Subject: Y/18/20/PL - Land E of North End Rd/W of Church Lane Nursery

I've just had a quick look at the application and note that your layout includes garages in the parking provision. I'm not sure if you have spotted this but our Parking Standards SPD states that garages are only to be treated as 0.5 of a space. Therefore, I calculate the total parking provision on the layout to be 12 spaces whereas the requirement would be 13 plus at least 2.5 (so 3) visitor spaces. Please can you consider this.

FLOOR PLANS

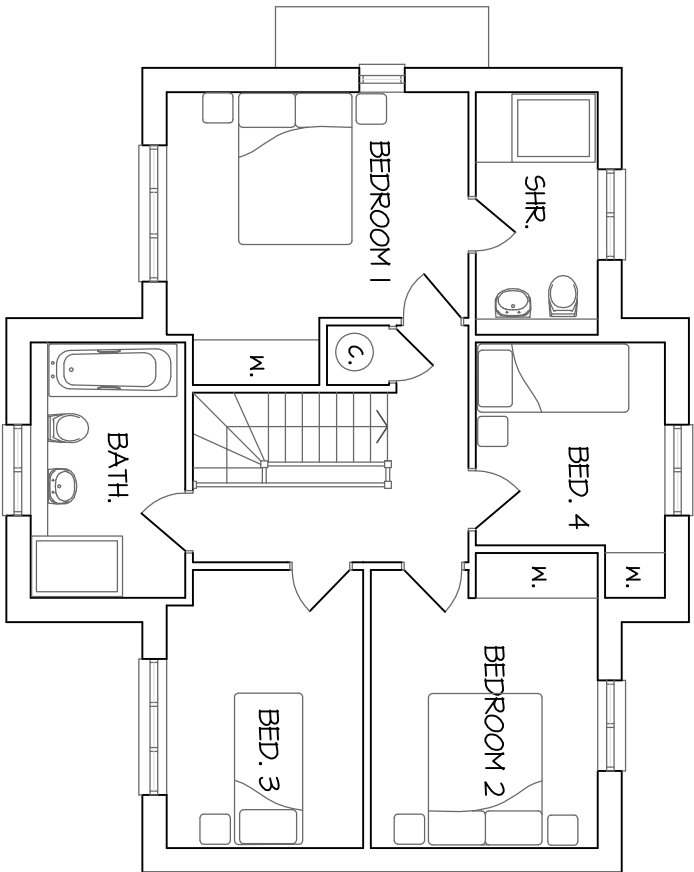
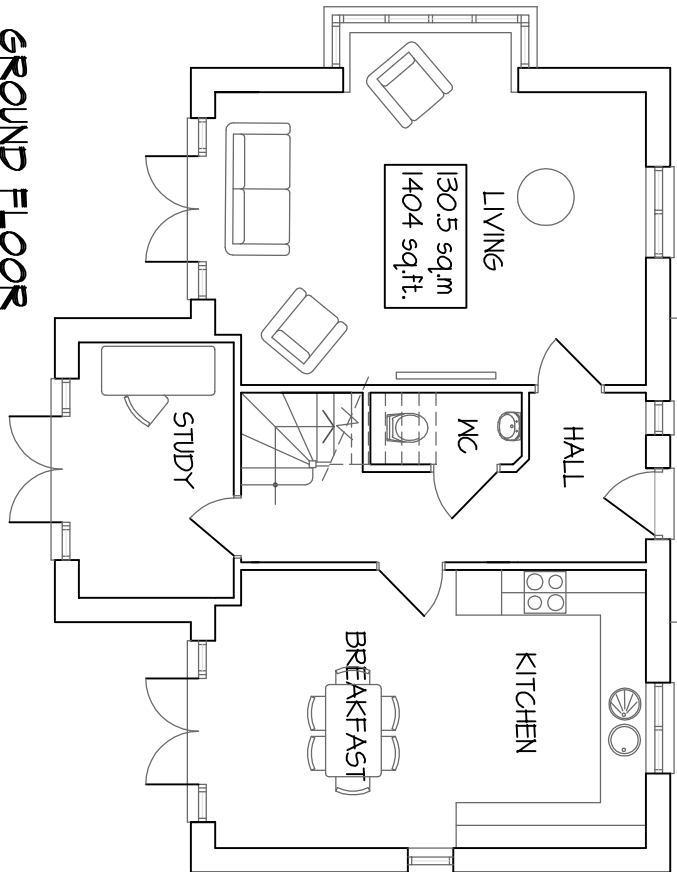
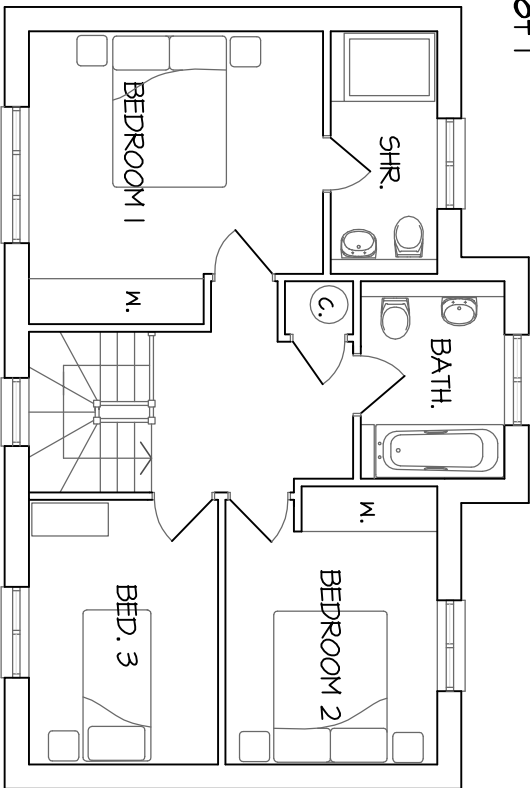
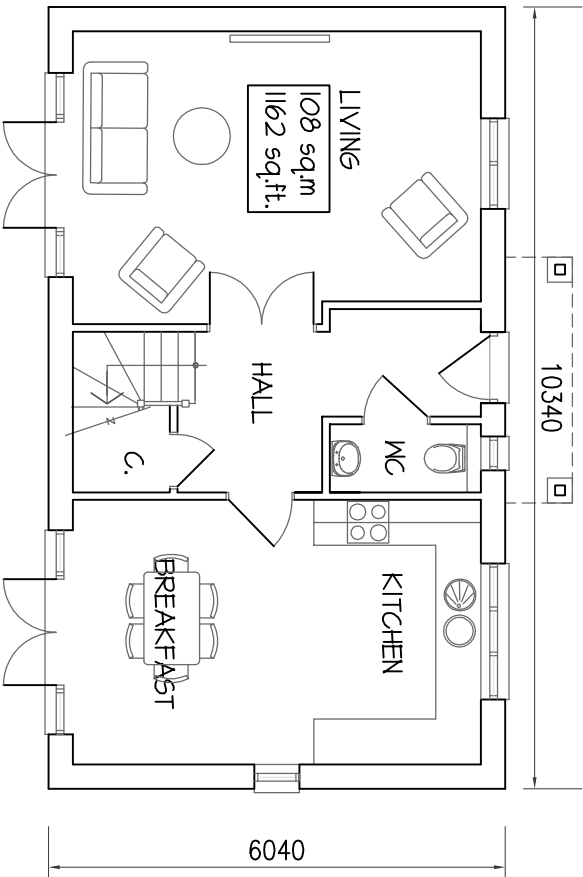
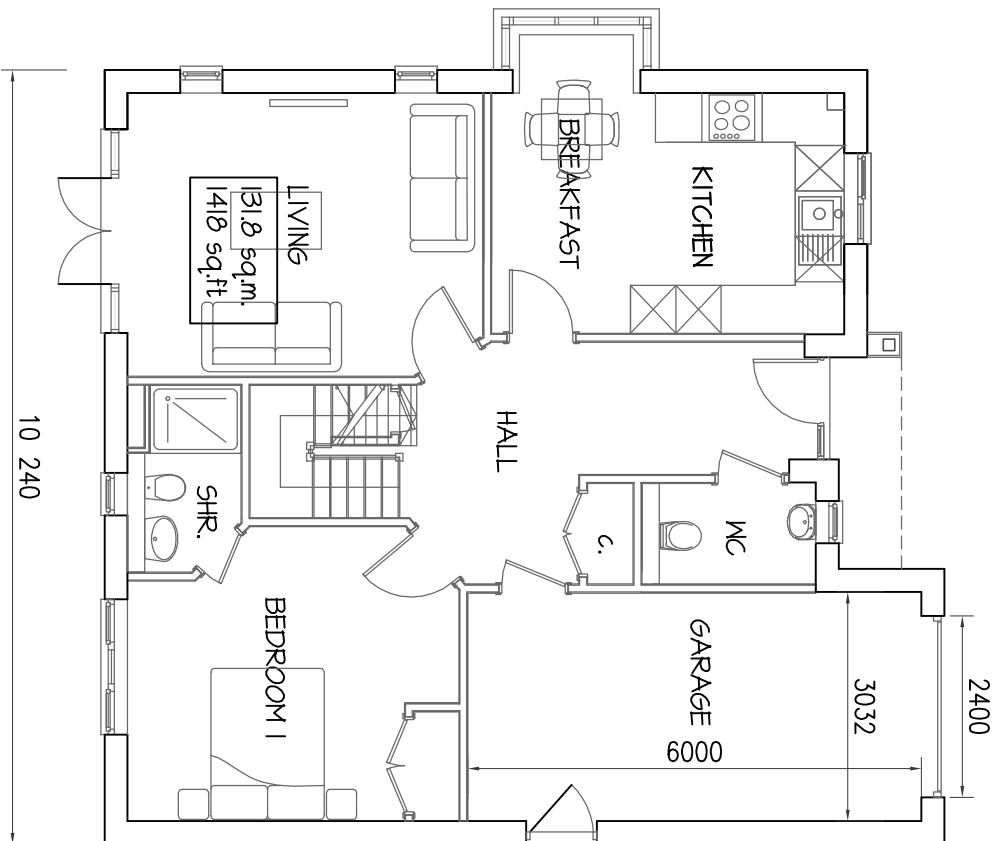
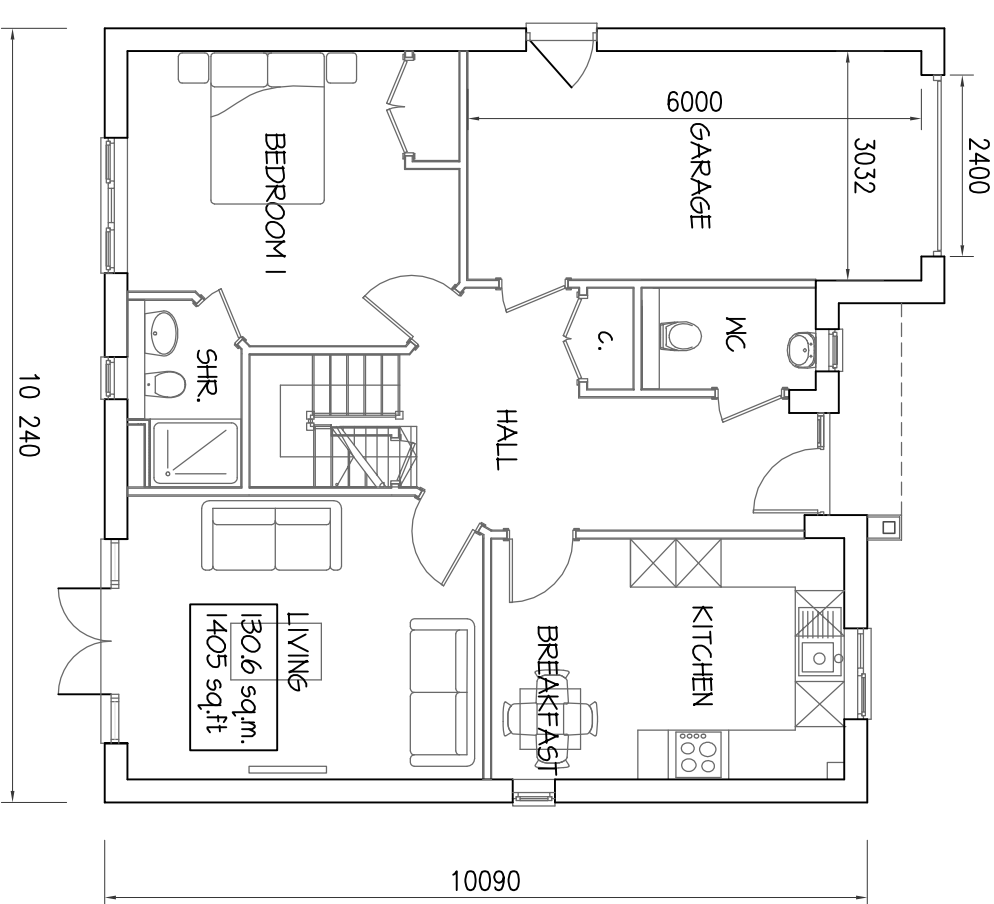
I'd also be grateful if you could provide an internal space standards breakdown for the proposed houses.
